BICESTERBUG

Comments on Planning Application 20/03404/F: Symmetry Park

6 January 2021

PLOT B - SITE PLAN AS EXISTING

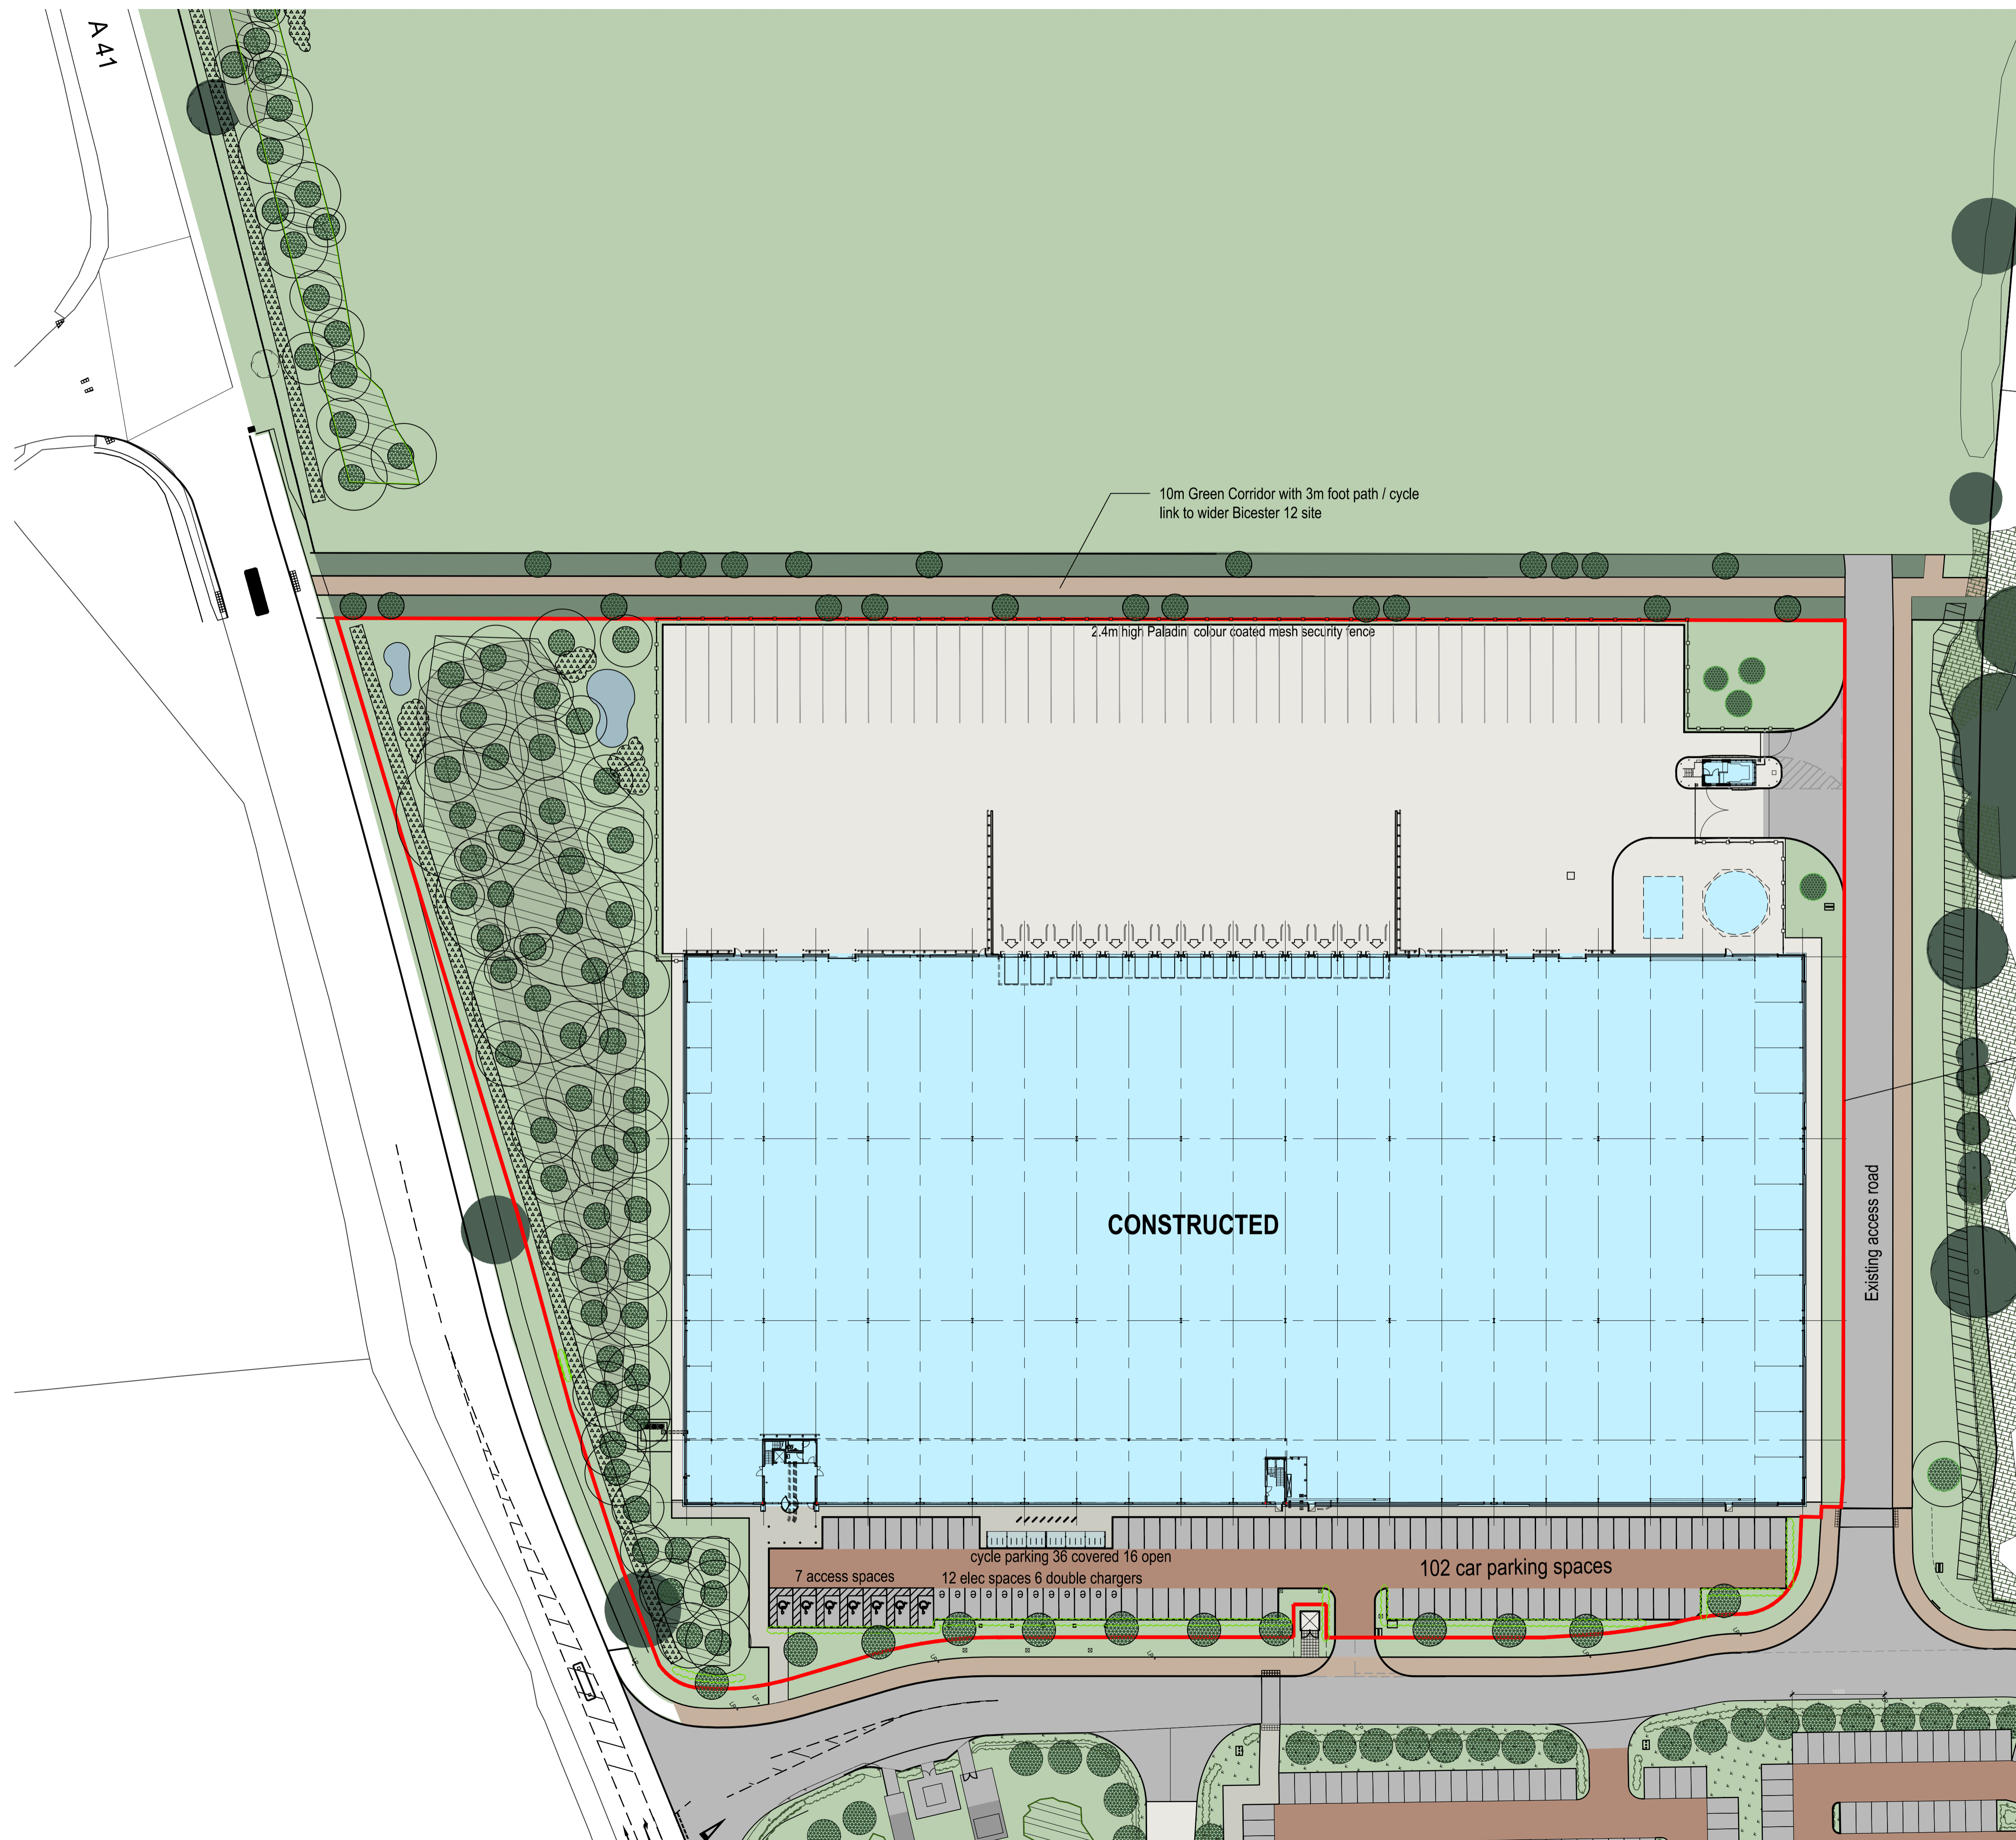
While it is theoretically possible to access the site by an off-road route, the route does not comply with any of the basic minimum standards for off-road pedestrian or cycle access and is effectively unusable.

At such high vehicle speeds, it is essential that there be a 'buffer zone' of horizontal separation between the carriageway and cycle tracks for safety and reassurance to users. At 50mph, Table 6-1 of LTN 1/20 recommends a desirable horizontal separation between the carriageway and cycle tracks of 2m, and insists on an absolute minimum of 1.5m. The OCC Cycle Design Standards require the same (3.2.7). While there is a short stretch of path on the A41 in front of the development, contrary to the requirement for segregation, this path has no horizontal separation whatsoever in the face of high traffic volumes and speeds, which is very intimidating to users.

LTN 1/20 also requires that pedestrian and cycle routes be segregated, not shared, because shared space is intimidating to vulnerable pedestrians, and discriminates against those with a disability such as the blind or partially sighted (6.5.4). The OCC Cycle Design Standards also require segregation (2.1.3 & 2.2.8). None of the paths along the A41 that could be used to access this development provide for segregation, they are all shared.

All of the relevant guidance requires a minimum width for safe and usable cycle and pedestrian facilities. LTN 1/20 requires adequate width (4.2.15). Bicester LCWIP recommends a width of 3.5m (p.21) and the OCC Cycle Design Standards insist on 2m or 1.5m at an absolute minimum (3.2.17). The Manual for Streets indicates that to accommodate only pedestrians, the absolute minimum width should be not less than 2m (6.3.22). The current path, which for the most part is on the opposite side of the A41 to the development and requires crossing a busy and dangerous road with no recognised crossing point, is a shared pedestrian and cycle path that is generally only around 80cm (eighty centimetres) wide. The path is in a poor state of repair, and given its trivial width, is almost impossible to use, let alone share with other users, and quickly becomes overgrown with encroaching vegetation. It is not accessible by disabled pedestrians, or many cyclists. A member of BBUG who is a tricycle user tried to use this route, but was unable to access it, and additionally suffered an accident. It is not a viable route.

At present, access to the site by pedestrians and cyclists is envisaged to be either via a 'green link' path or via the main vehicular entrance. The issue with the current proposal is that it requires pedestrians and cyclists to take an unnecessarily long and circuitous route where the route from the A41 to their destination as the crow flies is in fact very short. Such a long and circuitous route is not a problem for motor vehicle users, but is a significant disincentive for pedestrians and cyclists, and will discourage visitors from using this means of access.

A preferable design would be to permit pedestrians and cyclists to access the development at the closest natural desire line to the approach direction. A pedestrian and cycle access point at the western corner of the development would achieve this.

For these reasons, for this development to comply with the relevant policies, the applicant needs to provide or contribute to safe and viable pedestrian and cycle links consisting of segregated continuous (ie not

requiring users to cross the A41) and horizontally separated paths of adequate width.
